DOC19/55452
SSD 5175 MOD 6

Exhibition of Eastern Creek Business Hub, Rooty Hill Road South, Eastern Creek - SSD 5175 MOD 6 (Concept Plan)

Attachment 1 – Office of Environment and Heritage (OEH) comments Exhibition of Eastern Creek Business Hub, Rooty Hill Road South, Eastern Creek - SSD 5175 MOD 6 (Concept Plan)

**Figure 2 Comparison of approved and proposed Concept Plan**

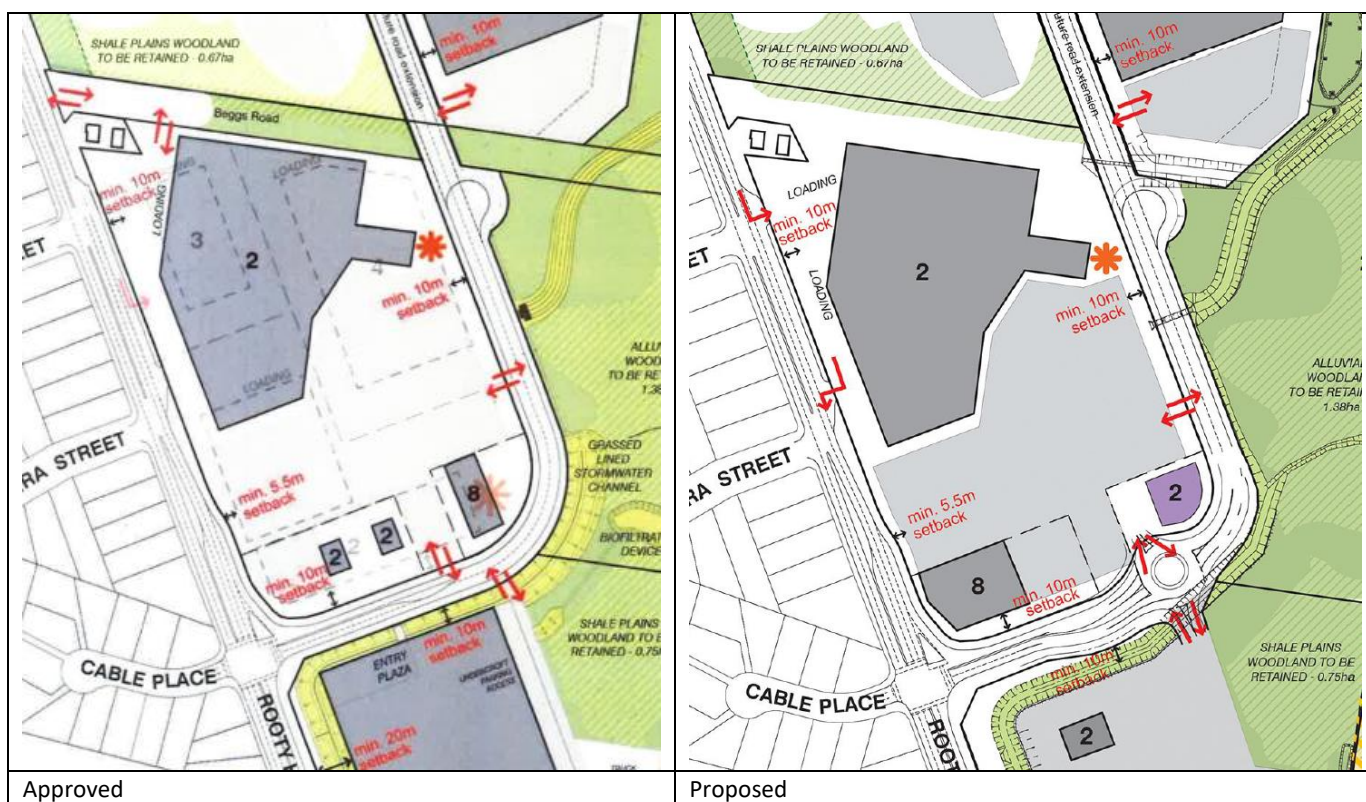
The Eastern Creek Business Hub Local PMF Assessment (JWP, June 2014) includes Figure 4.2 that shows the area relevant to proposed modification is fully inundated in the PMF flood. The area inundated affects both the existing approval and the proposed modification. The map shows no significant differences in flood depth between the child care location under the existing approval (location 2) and the proposed new location (location 8).

Child care development is classified as a vulnerable land use where users/occupiers would have difficulty or would be unable to self-evacuate in a flood event. Therefore, OEH recommends that an emergency response plan be prepared as part of the detailed design to ensure the safety of users in rarer flood events up to the PMF.

The Department of Planning and Environment is required to consider controls to apply to such types of vulnerable developments. These controls may include habitable floor levels to be above the PMF and structural soundness of buildings to ensure safe refuge of occupants within the facility.
